Planning Application Reference No.: 3/2025/0886

Address of Development: 5 Stanley court

Application reference: 3/2025/0886

Development address: 5 Stanley Court
Talbot Street
Chipping
PR33 2GE

3 PROPOSED EAST
1 : 50

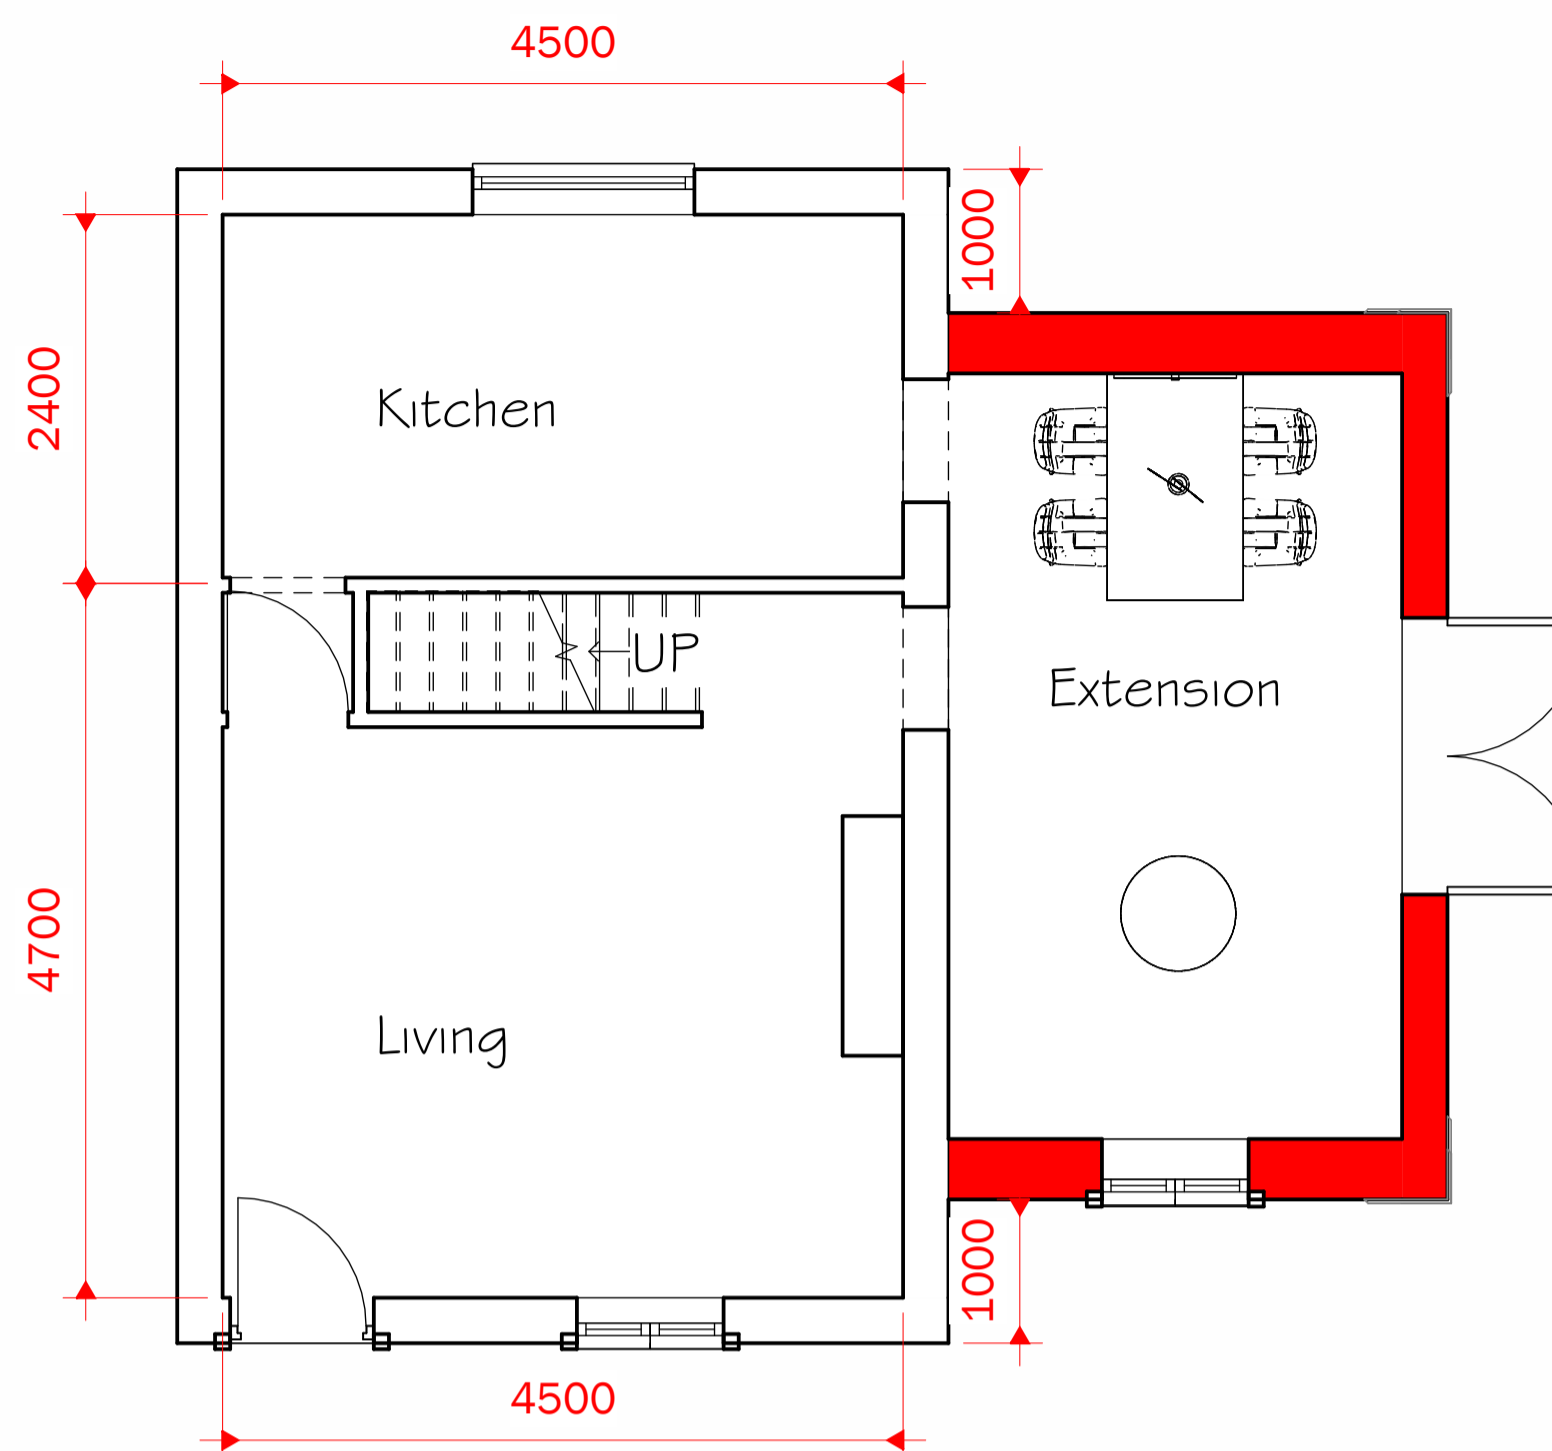
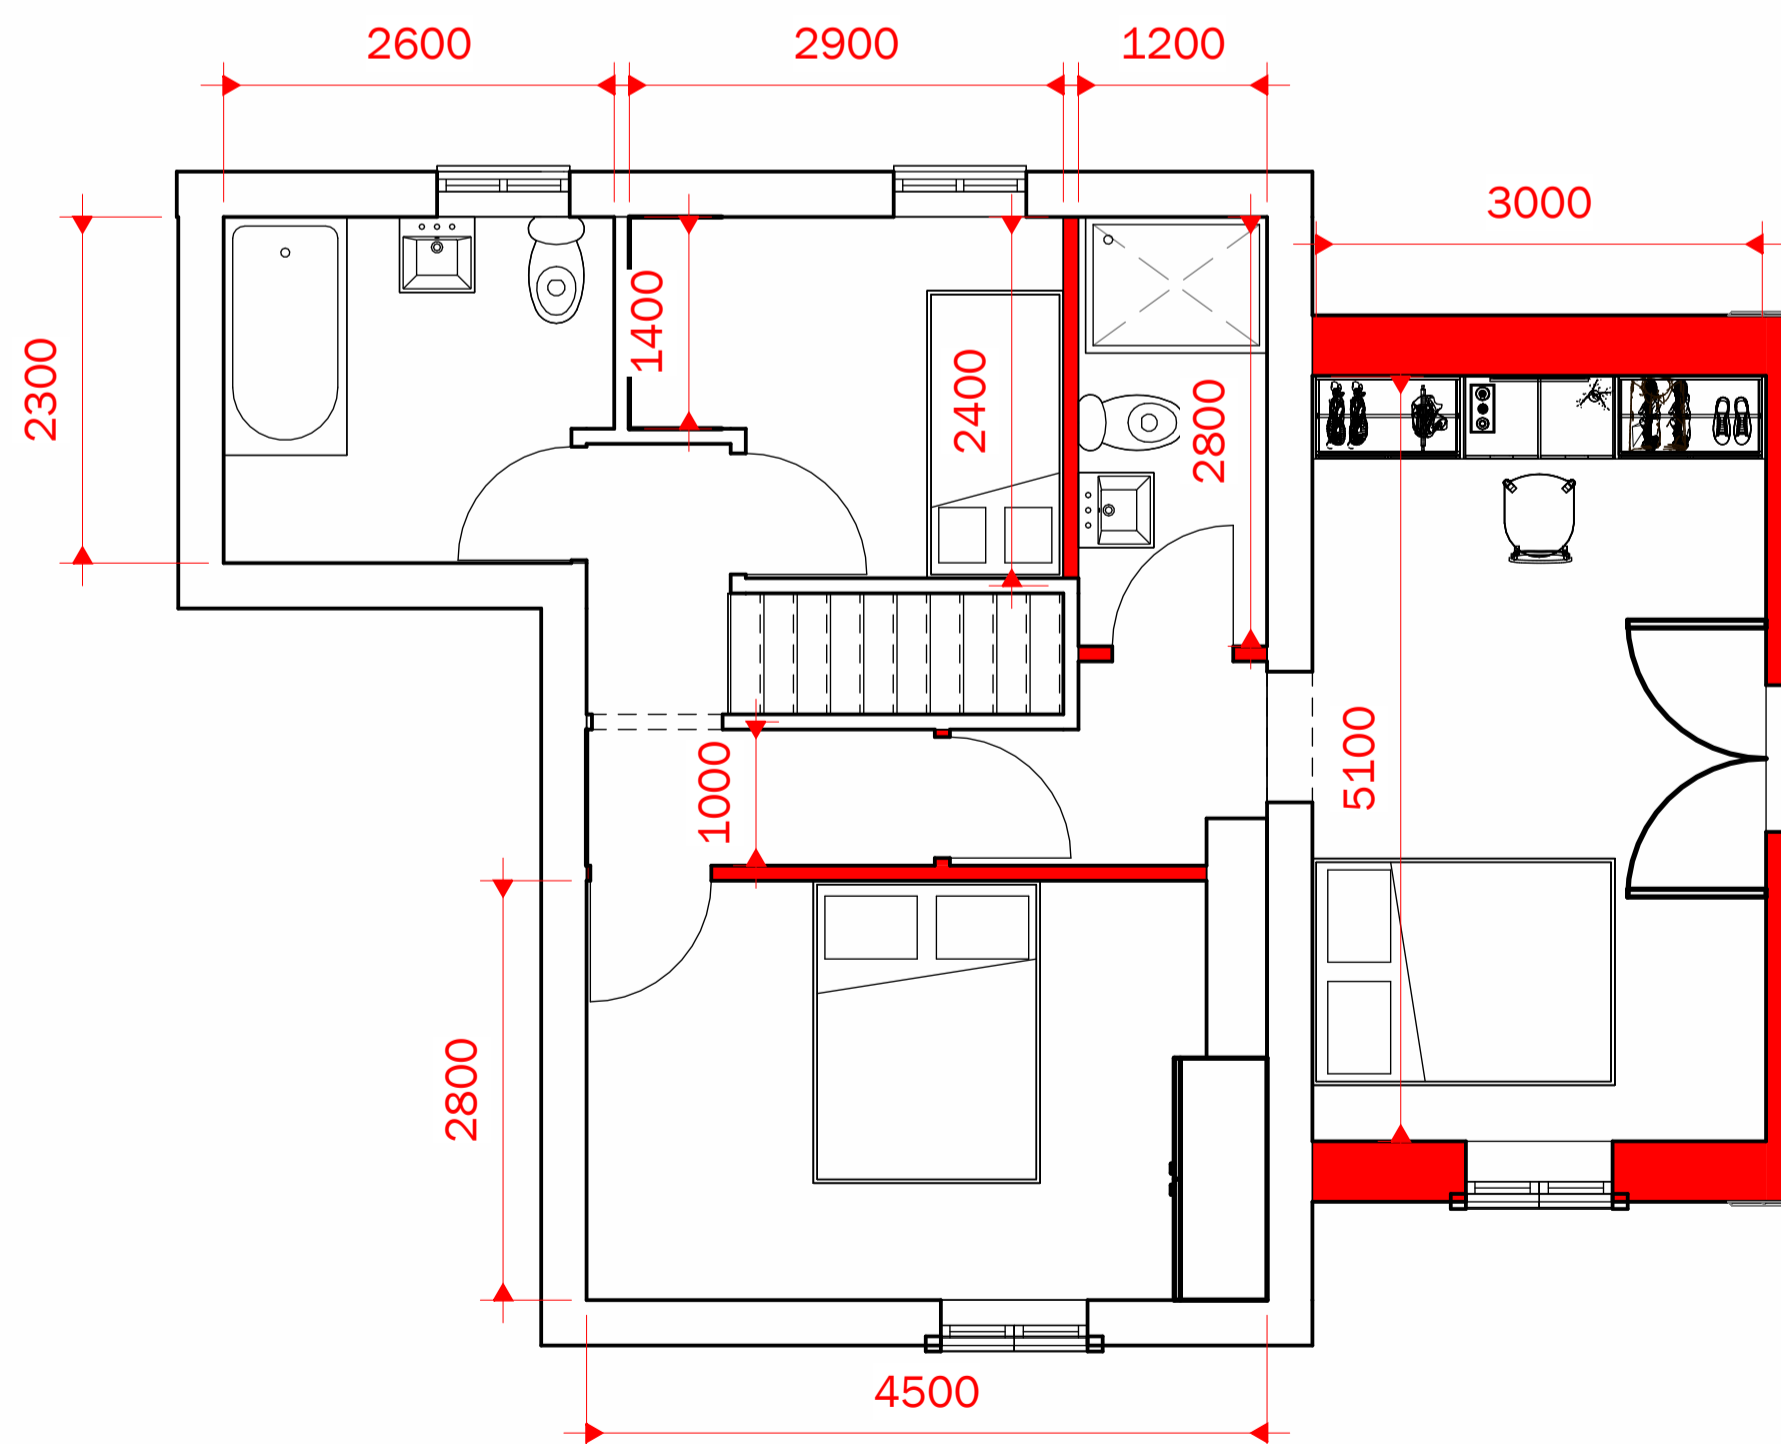
The scale of the proposed two storey extension is inappropriate in that it will nearly double the size of the existing property, making it look out of place within the courtyard. The rest of the properties in the courtyard are all small 17th century cottages in the Chipping Conservation Area.

The Juliet balcony on the eastern elevation will impact on the privacy of the resident's gardens and the pub gardens next door. Although the balcony might look good, I don't think it would be in keeping with the appearance of the other cottages in the courtyard.
